Sara Roach - Bega Valley Hospital - Stage 2

From: <greg.paine@industry.nsw.gov.au>
To: <sara.roach@planning.nsw.gov.au>
Date: 4/17/2013 9:33 AM
Subject: Bega Valley Hospital - Stage 2

1. Groundwater

## 3. IDENTIFYING A ZONE FOR GEOTHERMAL BORES

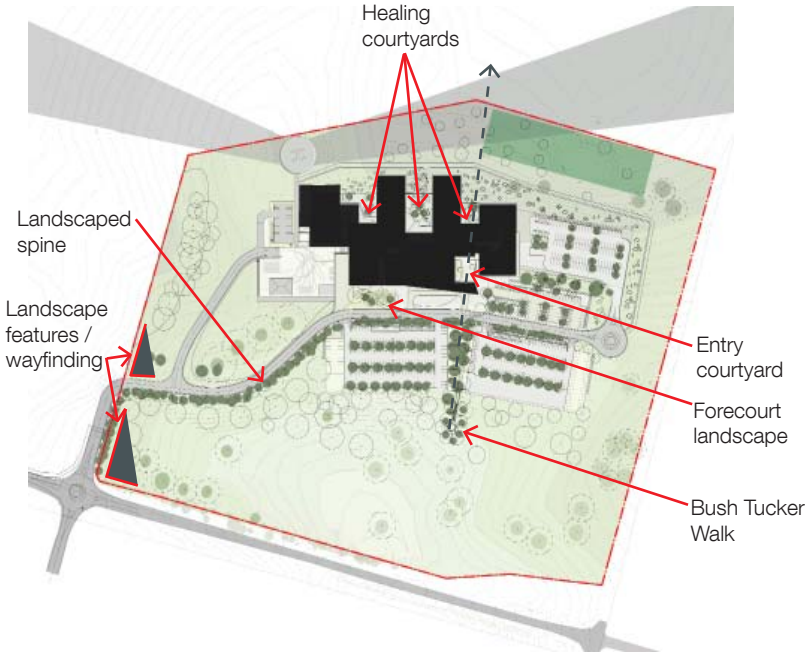
The proposed loop heat exchange system is deemed to be an **aquifer interference activity** under the *Water Management Act 2000*. That is, an activity involving any of the following: (a) the penetration of an aquifer; (b) the interference with water in an aquifer; (c) the obstruction of the flow of water in an aquifer; (d) the taking of water from an aquifer in the course of carrying out mining, or any other activity prescribed by the regulations; or (e) the disposal of water taken from an aquifer as referred to in paragraph (d).

The proposed heat loop exchange system works are likely to constitute an aquifer interference activity as a result of the penetration and possible obstruction and interference aspects of the installation.

It is apparent from recent studies by the Nebraska Grout Task Force that the integrity of grout used in constructed loop heat exchange systems may be suspect. That is, there may be significant opportunity for the contamination of the subsurface from additives used in the heat exchange solution through construction-induced fractures in the casing and in the grout or bentonite seal. In this regard, the geological consultant for the project (Coffey Geotechnics Pty Ltd) has identified a need for initial and ongoing periodic pressure testing of the system to identify the potential for solution leakage, as well as for purpose-built groundwater monitoring bores to identify any effects on groundwater quality.

A licence under Part 5 of the *Water Act 1912* will be required to authorise the construction and operation of the closed loop heat exchange system. Conditions will be placed on that licence that relate to construction of the bores and the ongoing monitoring and reporting of the system to demonstrate that it is not generating adverse impacts on any groundwater system. These are likely to include:

- geophysical logging of open (for additional strata information) and cased bores (to demonstrate casing and seal integrity).
- predictive modelling of thermal impacts on the subsurface for each seasonal circumstance and for all likely operational scenarios.
- inclusion of monitoring pipes within the host boreholes to provide the ability to demonstrate the ongoing integrity of grout seals.
- a testing program identifying the ongoing operational pressure testing of the system to demonstrate casing integrity.
- purpose-built monitoring bore installations external to the host boreholes at agreed locations to demonstrate that any impacts are isolated from the Bega-Brogo Alluvial Groundwater Source.
- a groundwater monitoring plan detailing agreed schedules, analytical suites and reporting arrangements.

1. A licence under Part 5 of the *Water Act 1912* is to be obtained from the NSW Office of Water for the heat exchange system, and the purpose built monitoring bores necessary to demonstrate the environmental sustainability of the project.
